## **'Parkview Place'**

7 Parkview Drive\_Sydney Olympic Park

Design Response> EA Submission

7 June 2010

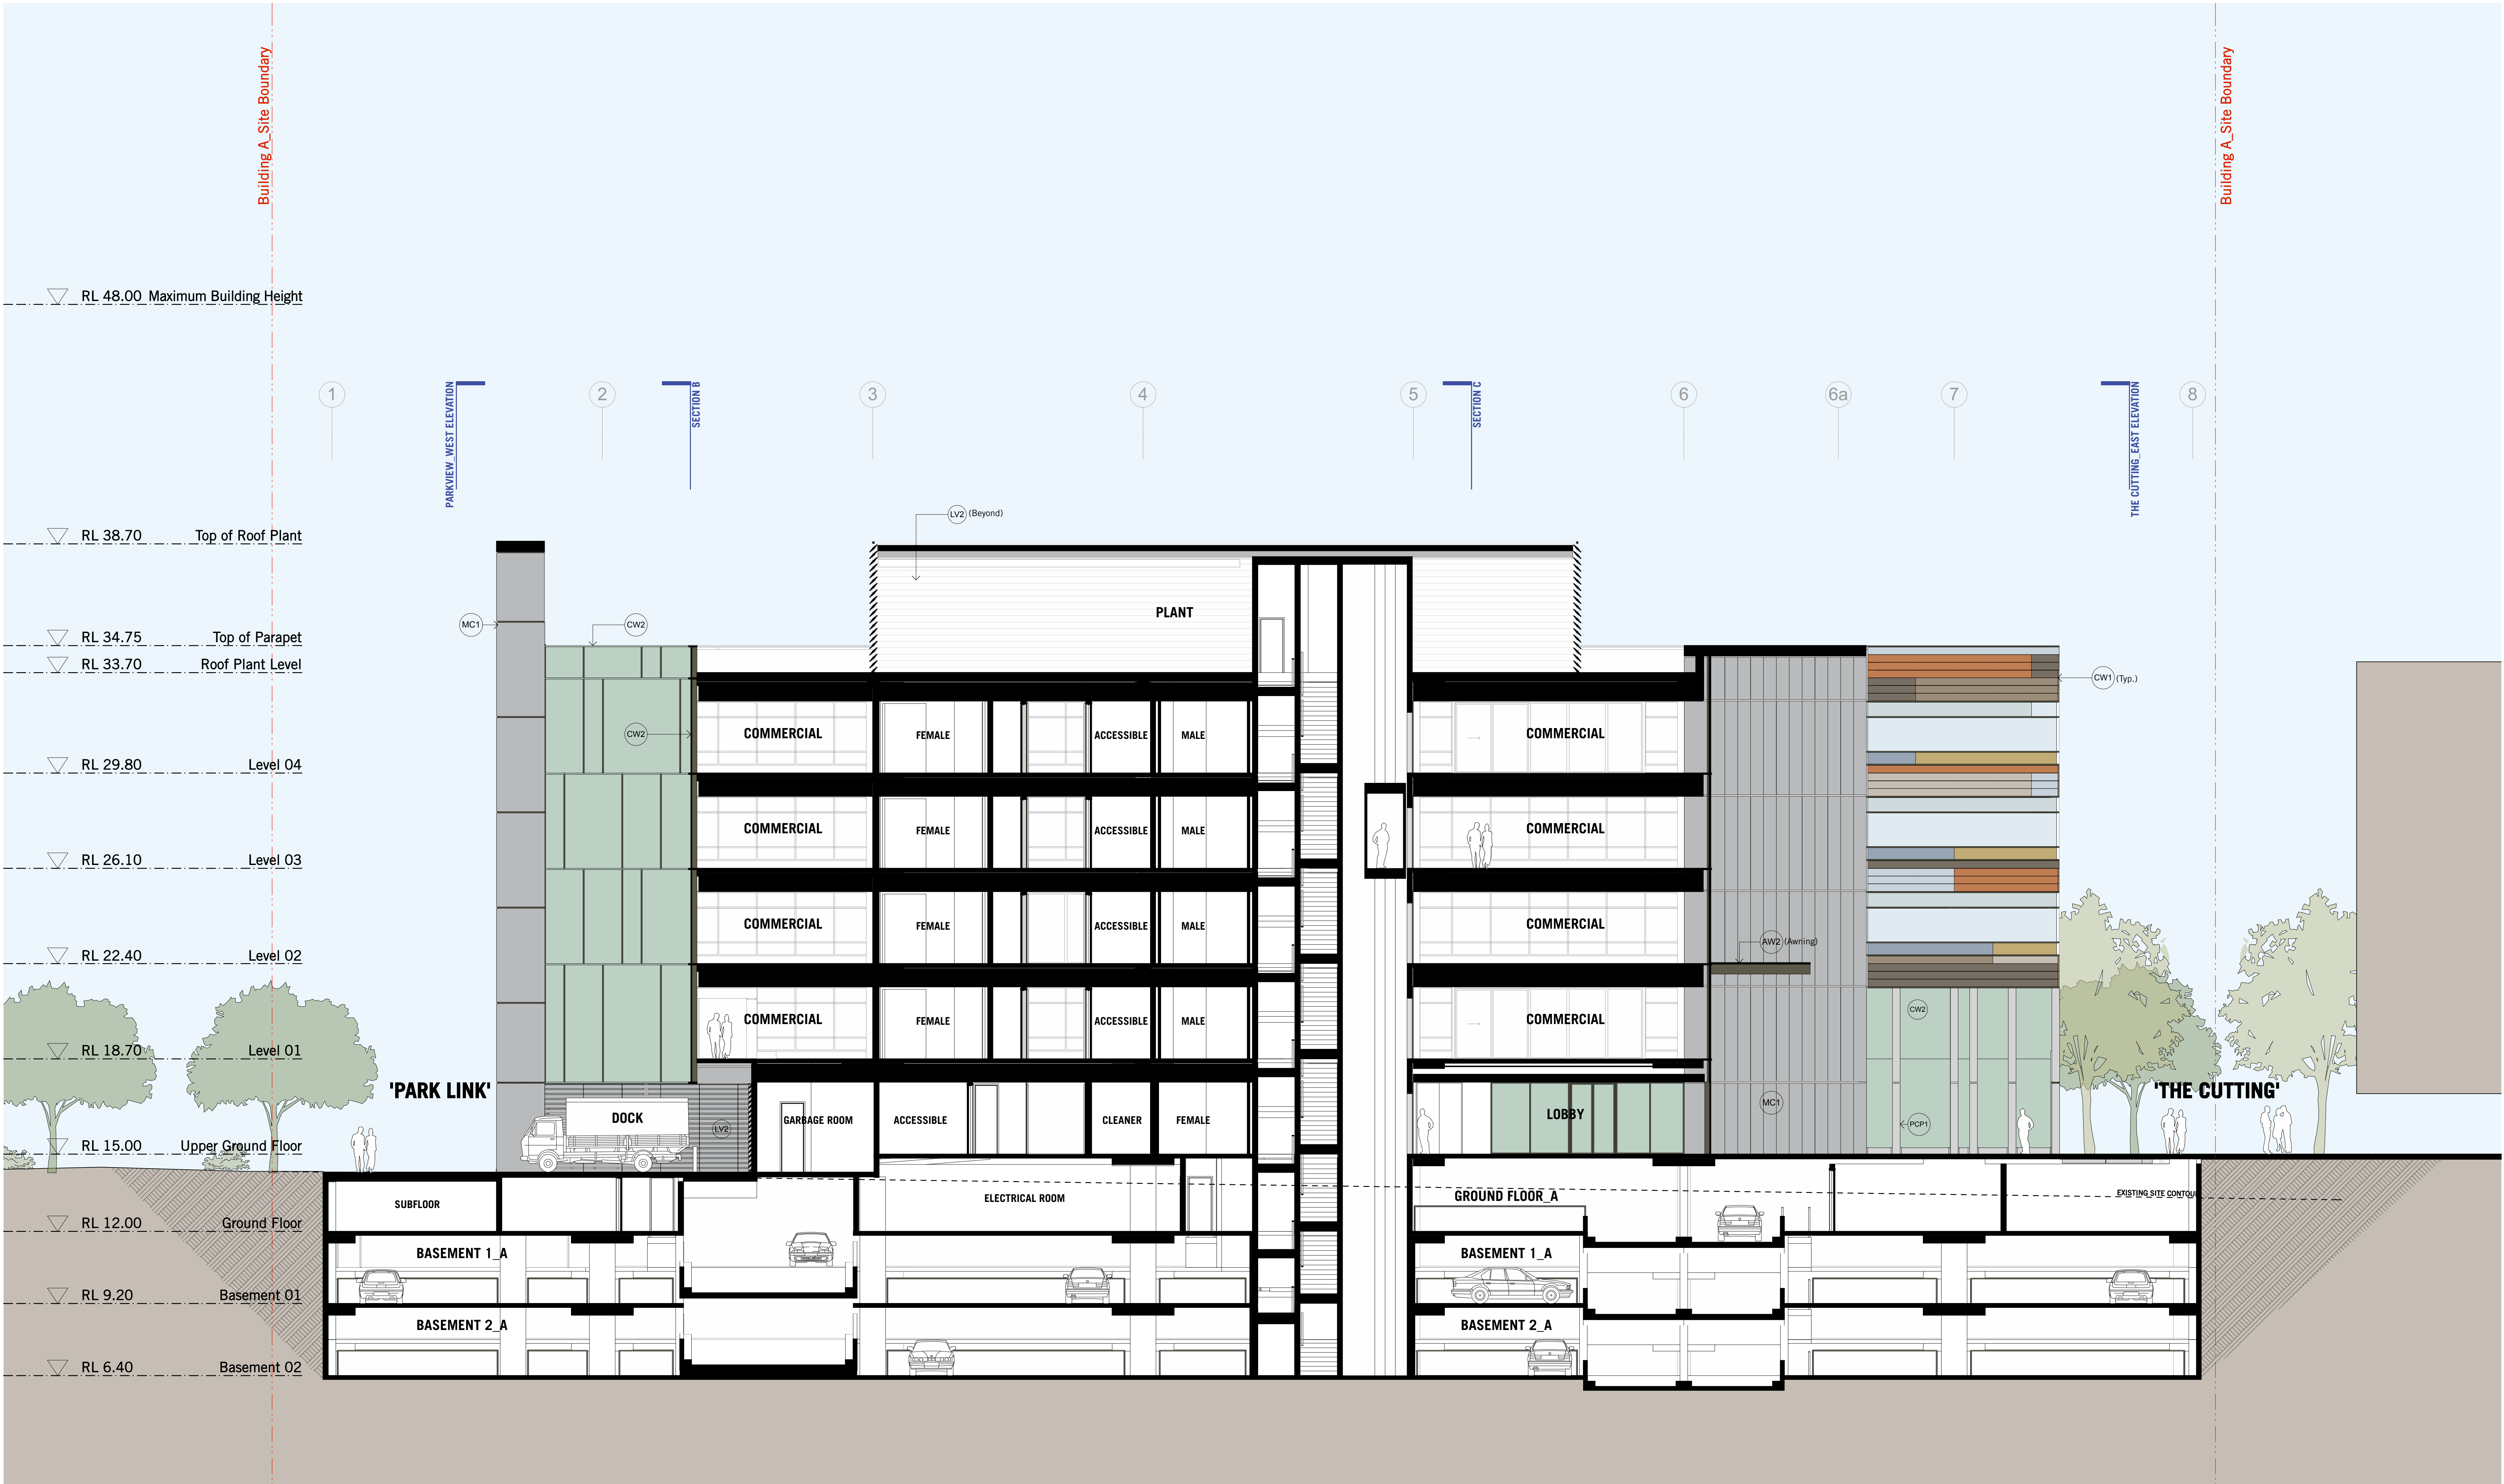
We provide the following response regarding the building form and articulation, in particular, the appearance of the Northern portion of the building as viewed from the Brick Pit Park.

We believe that the suggestion to provide a recessed ground level is unnecessary given the overall approach to the design including the clearly defined base, the 'gap' between and the variety of horizontal banding to the upper levels.

Taking on the hues of the geological profiles found on the site, terracotta inspired façade panels above ground level provide horizontal bands of varying natural colours between clear vision panels. The horizontal nature of the façade is further reinforced where fixed horizontal louvres, 'extruded out' of the building form, provide solar protection.

Dispersed across the northern façade deep balconies provide a break in the horizontal banding of the terracotta façade panels. The balconies, positioned to respond to internal group work space areas, permit outdoor activities, whether private or communal and assist in reinforcing the connection to the park. Jump scale 'bay windows' positioned at the corners of the façade frame views across the park.

As demonstrated in the perspective images accompanying the EA submission the solid base wraps around the building and is sculptured to respond to the changing ground plane condition and movement patterns around the site. Given the change in levels, on the northern side the building base forms the sill to the ground level rather than the larger visible portion to Murray Rose Avenue or the 'cutting' to the east.

Ground level windows sit on top of the building base and are articulated vertically. Full height uninterrupted panels provide relief between the heavy base and the horizontal banding to the upper levels. Furthermore, clear glass is used in lieu of the various tones of tinted glass over.

This treatment to the building articulation is used around the entire perimeter of the building to provide a clearly defined 'gap' between the base and upper portion of the building.
